Arun District Council
Arun Civic Centre
Maltravers Road
Littlehampton
West Sussex BN17 5LF
Planning & Building Control General Enquiries
Tel: (01903) 737756 Fax: (01903) 730442
Dx: 57406 Littlehampton
Minicom: 01903 732765
e-mail: planning@arun.gov.uk
website: www.arun.gov.uk/planning

Application No: FG/34/21/HH
Site Address: 50 Ocean Drive Ferring BN12 5QP
Description of works: 1st floor side extensions, two storey front extension, side and rear extensions, installation of balcony to rear and 2 x front dormers including demolition of existing garage.

Thank you for your internet representation made on 20th March 2021 which has been recorded as an objection with the comments as follows:

1st FLOOR PLAN

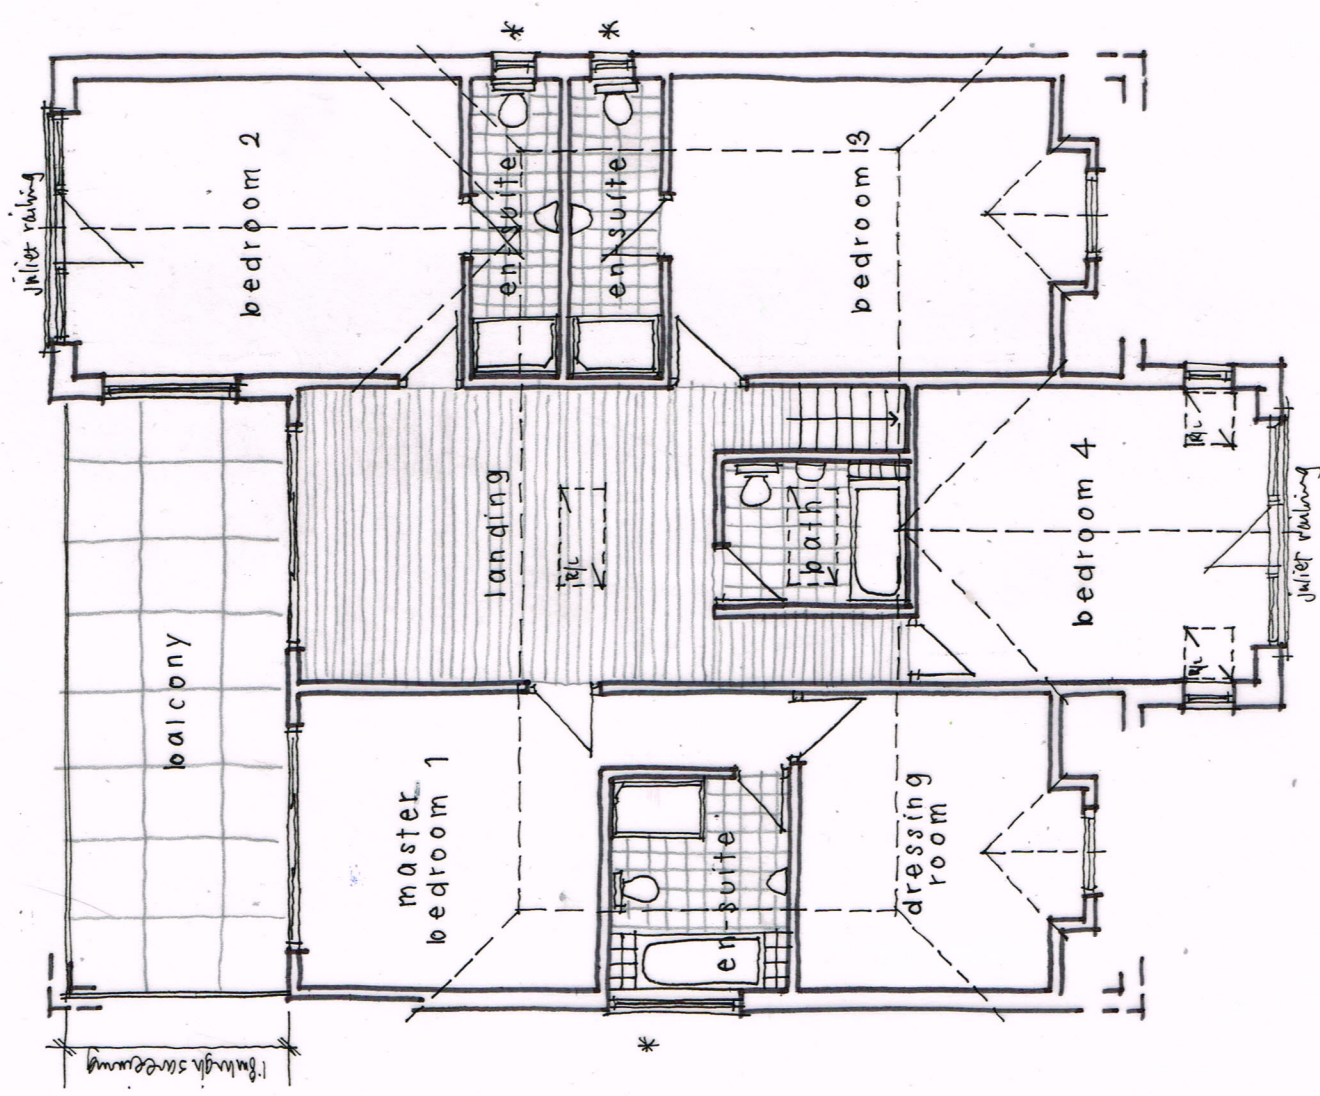
Ferring Parish Council objects to this proposal with particular concerns regarding the first floor balcony. The size and mass of the development is significant, creating an overbearing presence on its neighbours. The inclusion of a large first floor balcony which overlooks neighbouring back gardens will be imposing and depriving neighbouring residents of the privacy and level of seclusion they currently enjoy when utilising those outdoor spaces. The gardens are valuable features of the properties and overall setting which creates the distinctive village identity which is in contrast to the more intensively developed adjacent settlements.
